From: [REDACTED]
Sent: 12 April 2012 11:15
To: lwrightman@chichester.gov.uk
Cc: Anita Gardner
Subject: The Old Barn - Ferring - Application No. FG/6/12 & FG/4/12/L
Attachments: Drawing 3214-006 Rev C.pdf, Drawing 3214-009 Rev E.pdf, Drawing 3214-010 Rev E.pdf, Drawing 3214-011 Rev D.pdf

RE: The Old Barn - Ferring - Application No. FG/6/12 & FG/4/12/L

Further to yesterday's telephone discussion, please find attachments with Febo Designs revised drawings No's 3214-006 rev C, 3214-009 Rev E, 3214-010 Rev E and 3214-011 Rev D.

DRAWING NO.	DRAWN	SCALE	DATE	REV.
3214-006	AF	1:100 A1	April /12	C

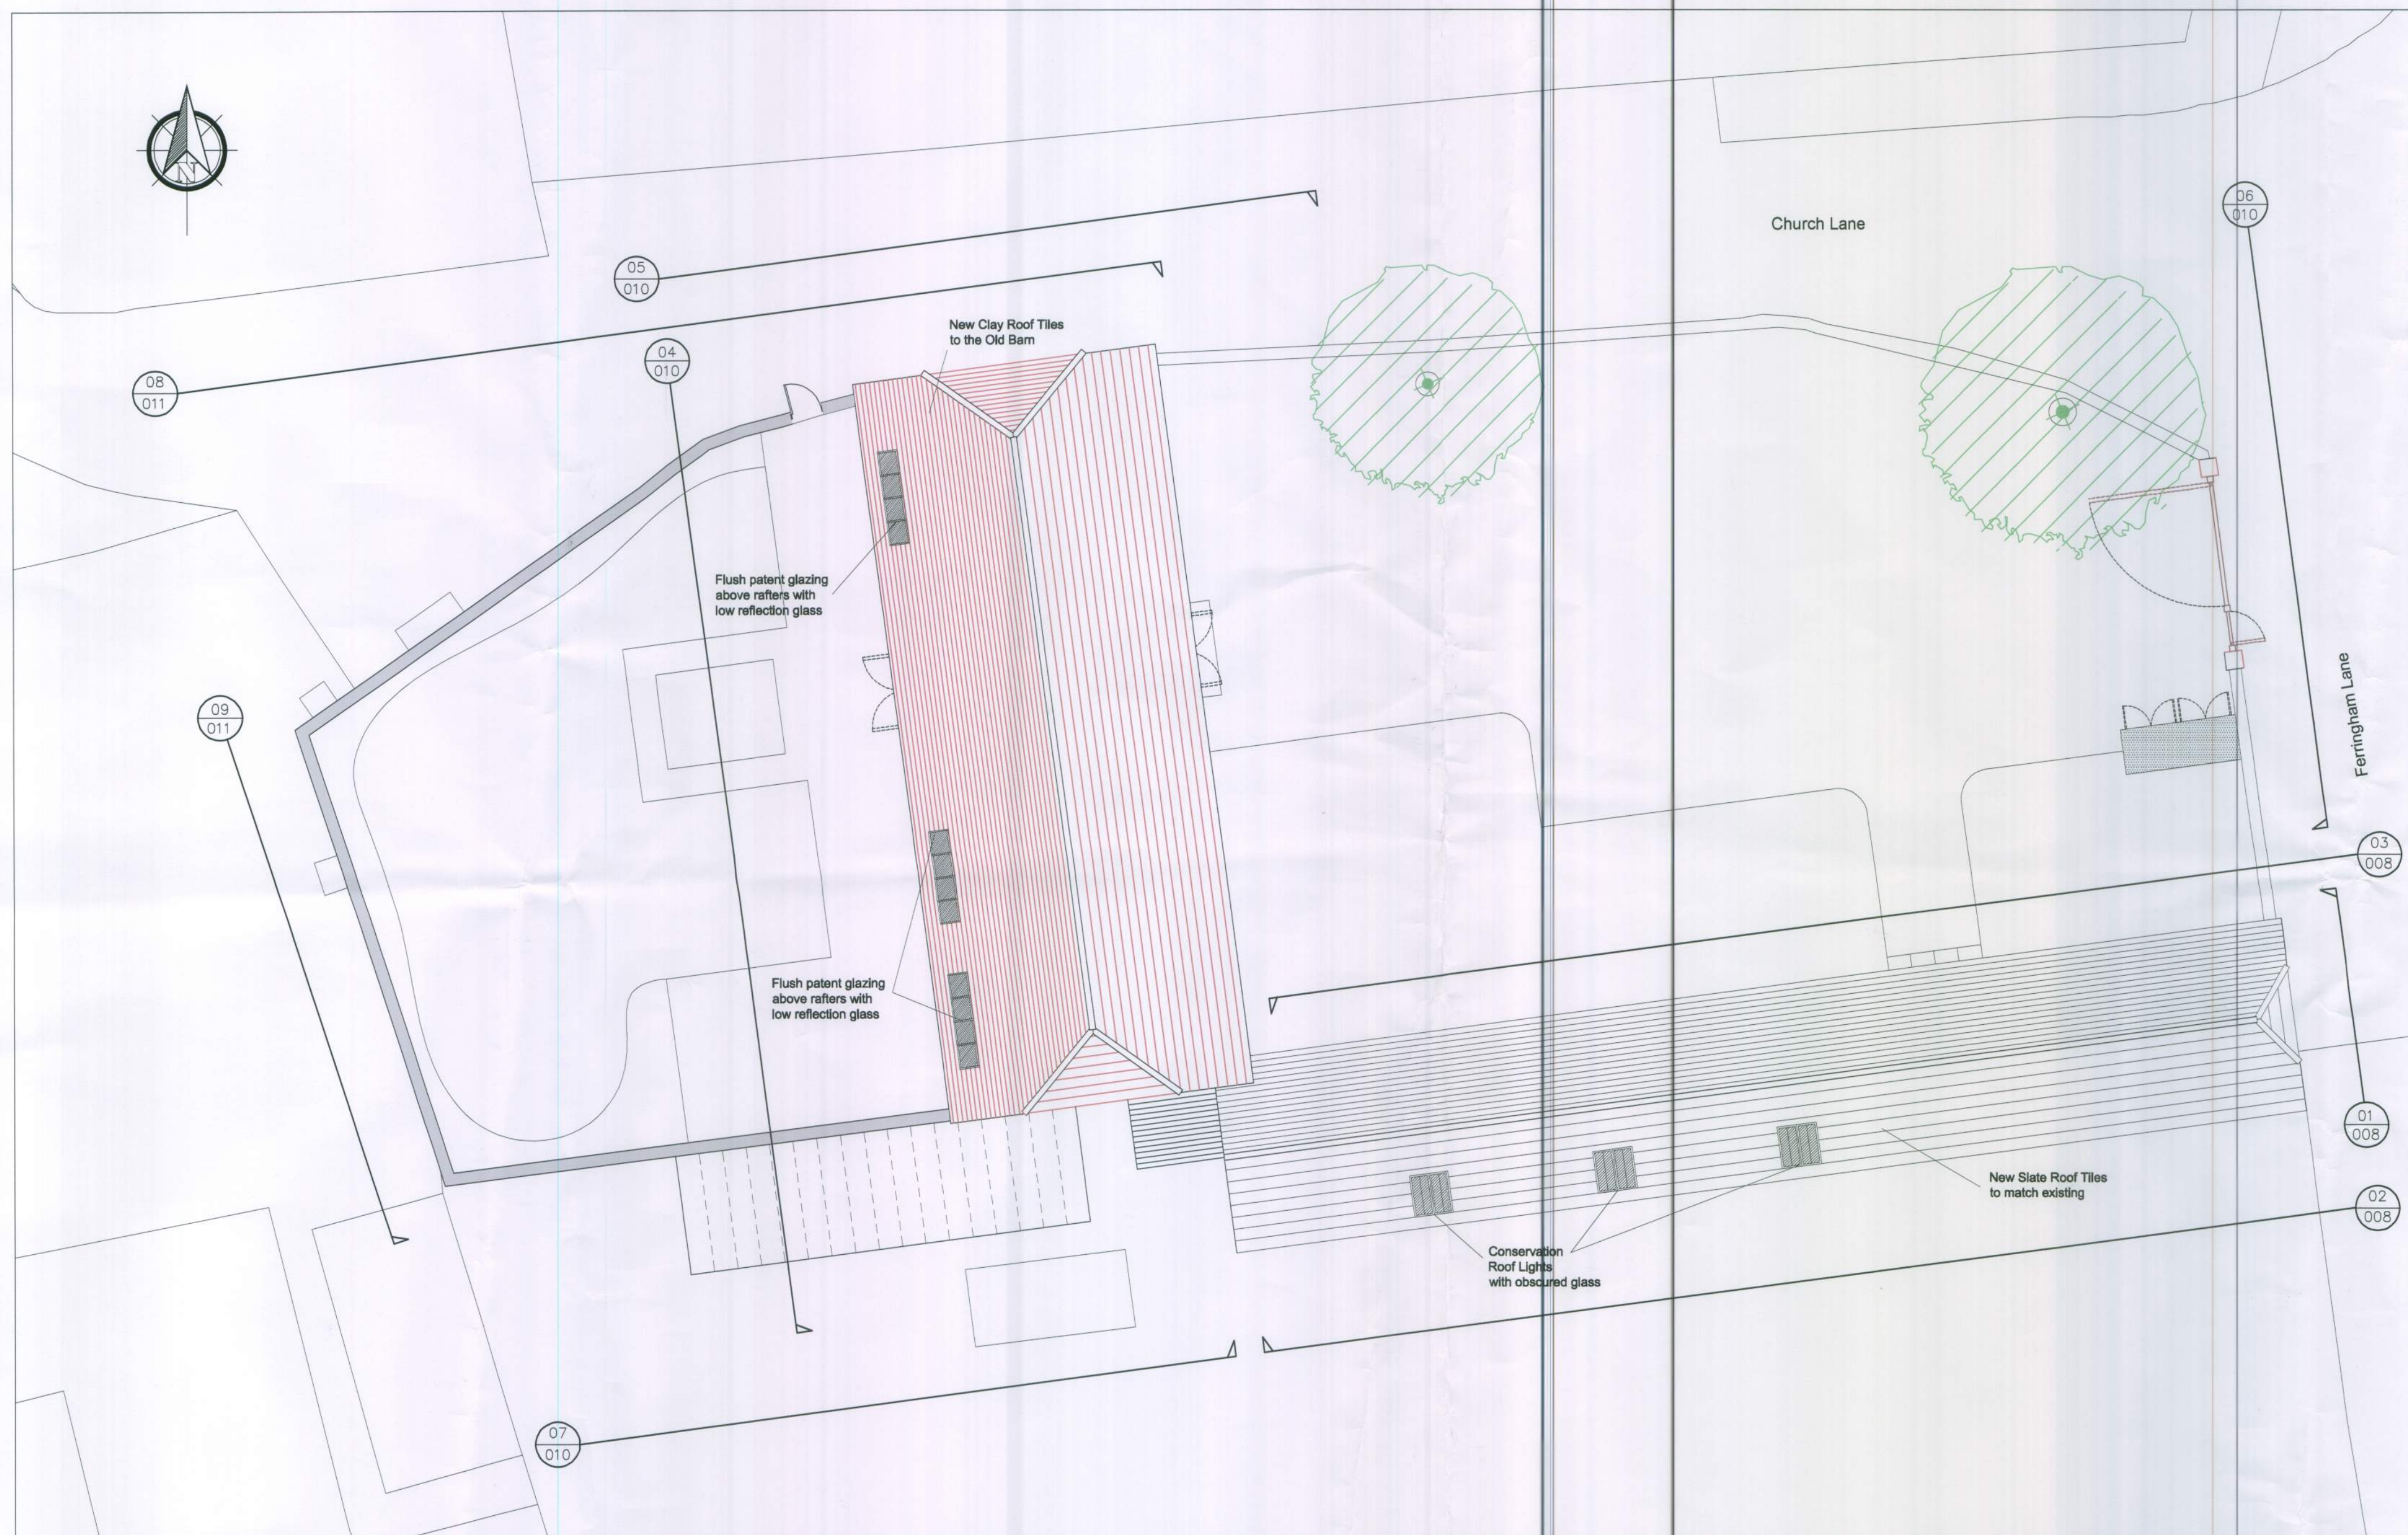
1. The Patent Glazing over the west entrance has been removed
2. The internal glazing to Bedroom 2 has been extended
3. The Study's partitions have been chaged from solid to glazed construction
